RE: Renard Trust

File: ADM-22-37

A request has been made for an interpretation regarding the above referenced parcel to confirm that the property is considered a legal division of land pursuant to the El Paso County Land Development Code. A request has also been made to confirm whether setback encroachments of various buildings can be considered a legal nonconformity.

# SITE PLAN

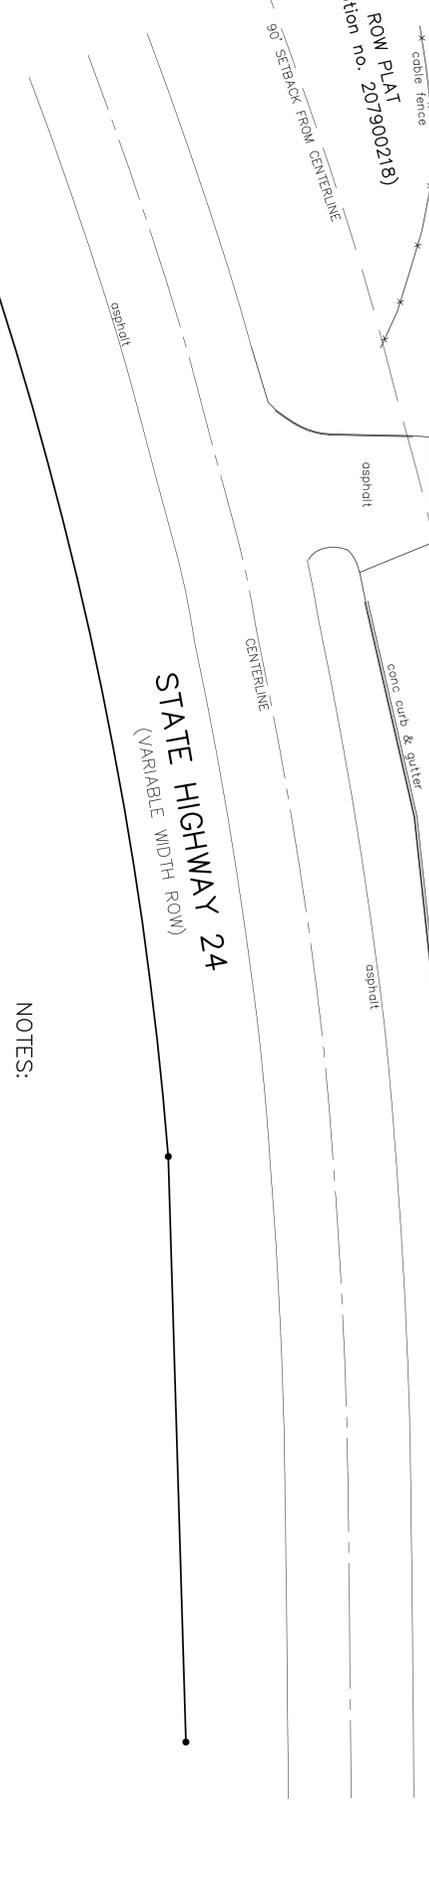
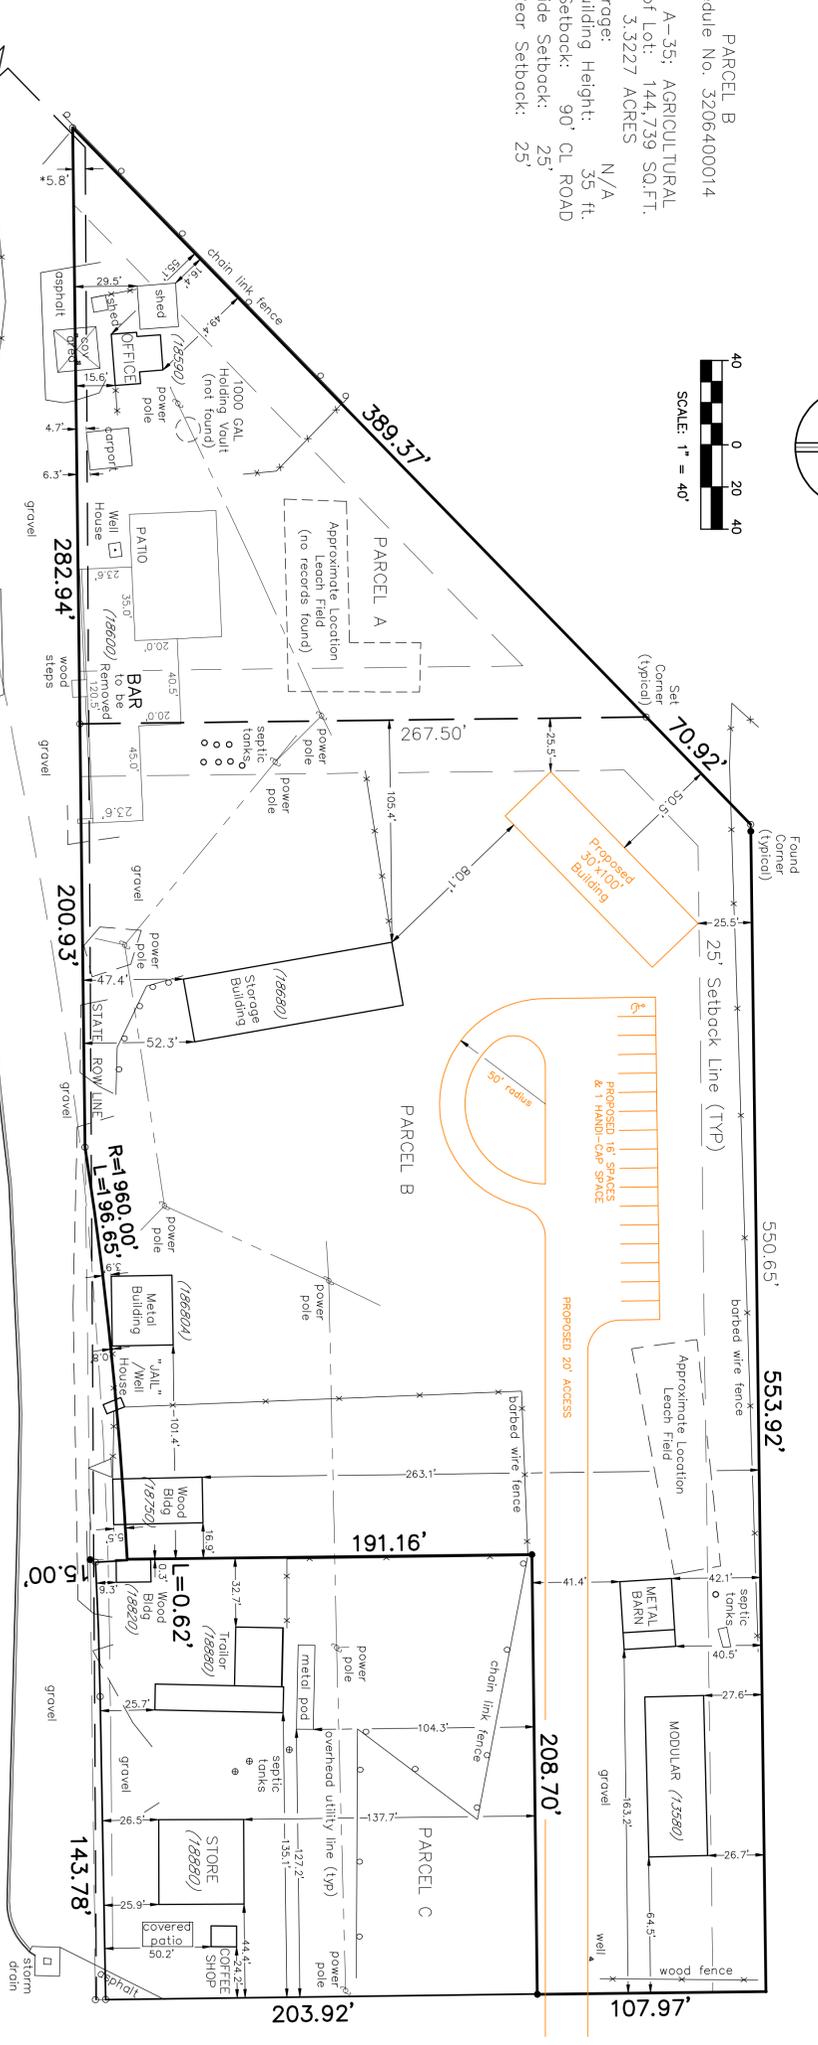
Building 1 on the property was constructed in 1999 and meets setbacks for A-35 zoning (25 feet). Building 2, the “Repair shop” was built in 1970, has a rear setback of 3.9 feet which does not meet setback requirements of A-35 zoning. Building 3, the mobile home, which is rented

on the property and does meet the setback standards of A-35 zoning (25 feet). However, the rental of the mobile home is not allowed by code. Building 4, the "Office," meets the setback requirements of the A-35 zoning district. Building 5, the convenience store, does not have a building date, however, it does meet the setback requirements for the zoning district. Building 6, is a proposed building that will meet the zoning setbacks. The use of a "bar" is not a permitted use in A-35 zoning. Lastly, building 7, a small shed, does not meet setbacks for the zoning district.

This property was initially zoned A-35 on March 24, 1999, buildings 1 and 2 can be considered legal nonconforming in relation to when zoning was established in 1999. However, buildings 3, 4, 5, and 7 do not have any building dates on file with the planning department, therefore it is recommended to acquire building permits for the associated buildings. Buildings 1, 3, 4, 5, and 6 do meet zoning setback standards for the A-35 district. Building 7, "shed" that is northwest of the "office" is encroaching into the setbacks by 8.6 feet.

Due to the master parcel being created prior to July 17, 1972, this can be considered a legal nonconforming parcel. However, the subsequent parcels created from the master parcel were created after 1972 and did not go through the subdivision process, making them illegal parcels. It is recommended to legalize the parcels that they through the minor subdivision process to create legal lots. The size of this parcel is 4.18 acres, which does not meet the lot size standards for A-35 zoning and it is recommended to seek approval from the Board of Adjustment for a lot size variance. Additionally, building 7 does not meet setback standards and a variance is recommended for setback encroachment, or remove the building. The other buildings on the property do meet setback standards. The proposed building as depicted on the site plan is within the setbacks for the A-35 district. However, it must go through proper zoning applications prior to obtaining a building permit. Lastly, the mobile home that is being rented is not an allowed use, and it is recommended that the property owner cease the use or move forward with a Variance of Use for a rental on the property.
